Recommendation Report for Planning Permission for Works or Extension to a Dwelling

REF NO: P/102/21/HH

LOCATION: 42 Greenways
Pagham
PO21 4QE

PROPOSAL: Single storey rear extension including demolition of existing conservatory and garage

Proposed Floor Plan 1:50

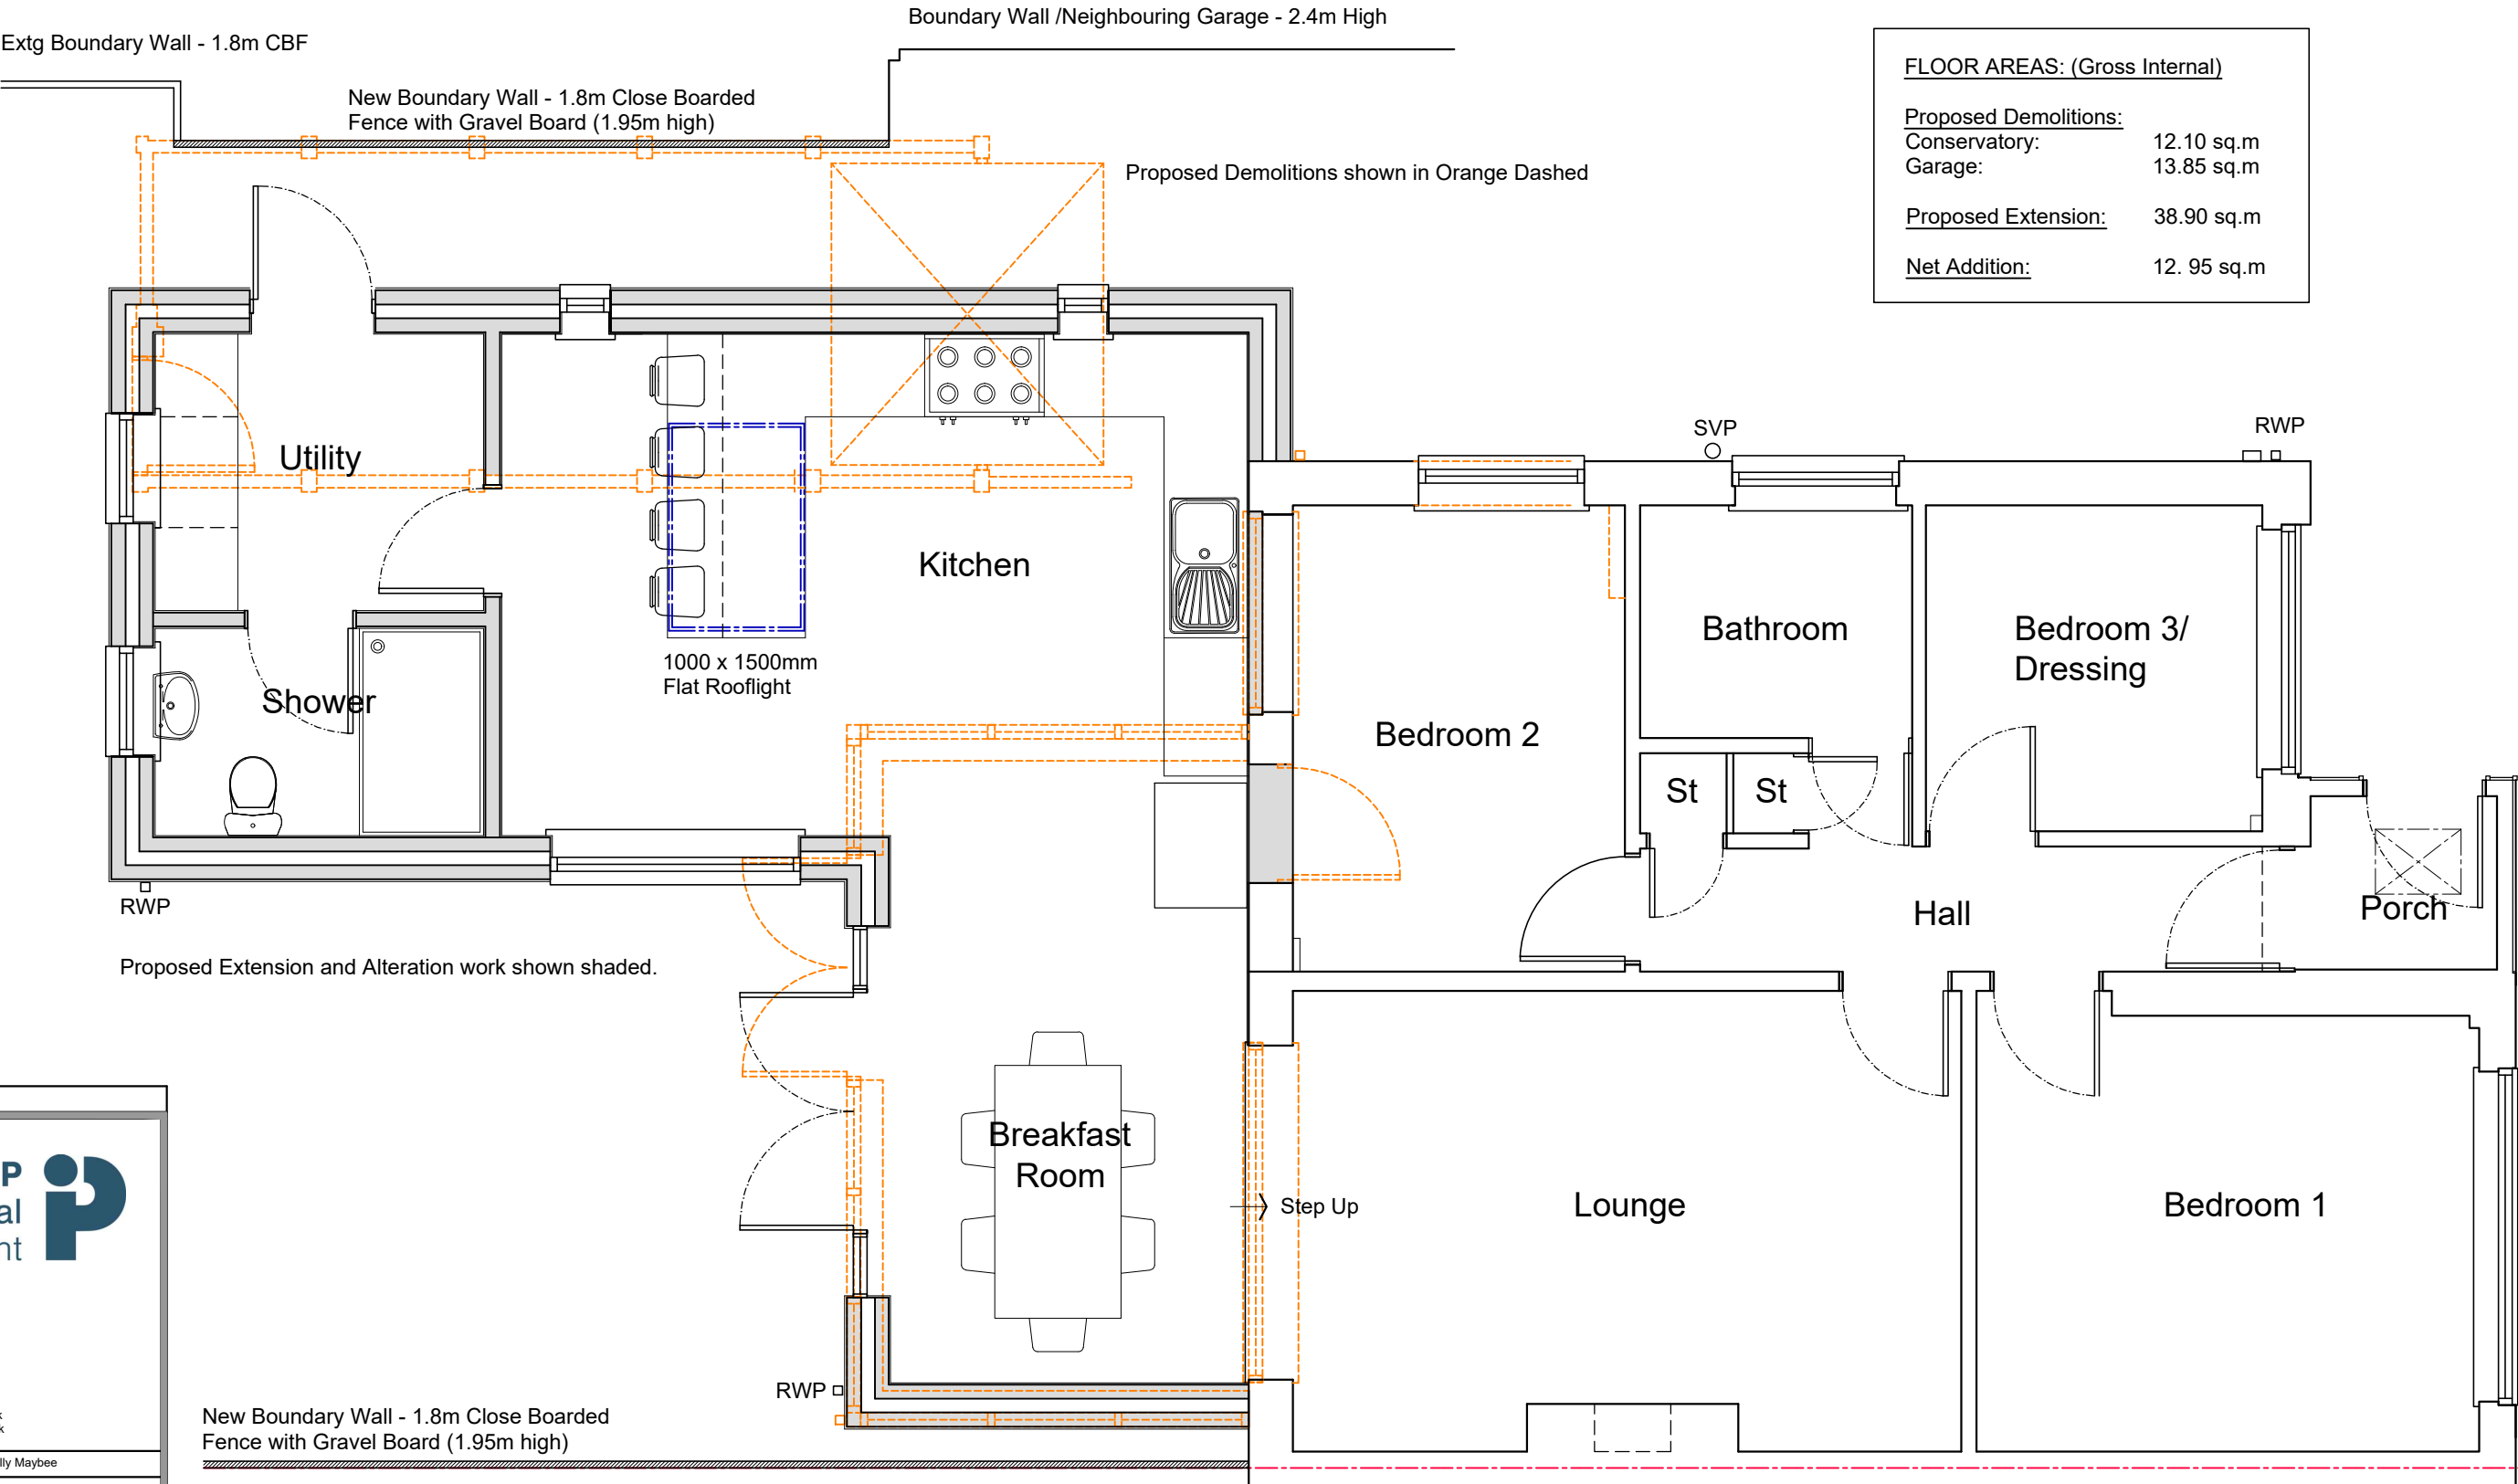
The extension will have a depth of 3m to the rear elevation which will increase to a maximum of 8.25m. The depth of the extension matches that of the existing conservatory and garage that will be removed although extends slightly further west to join with the host dwelling. The width of the extension, sited in replacement of the garage will increase however retains around 4m to the northern boundary. The height of the extension will be a maximum of 2.85m which is considered modest and acceptable.

To the north, the extension will be in the same footprint as the conservatory and is not considered to result in adverse harm. The extended bulk of the extension is sited 4m from the boundary and is sufficient to ensure there is no adverse overbearing.

There will be 2 windows to the southern elevation however these are small in size and will have views of the neighbouring garage. There will be new boundary fencing to a height of 1.95m to further restrict views. 1 window will be to the northern side and doors and a windows to the east. These will have views over the garden of the host dwelling and are not considered to increase from that which are already available from standing in the garden.
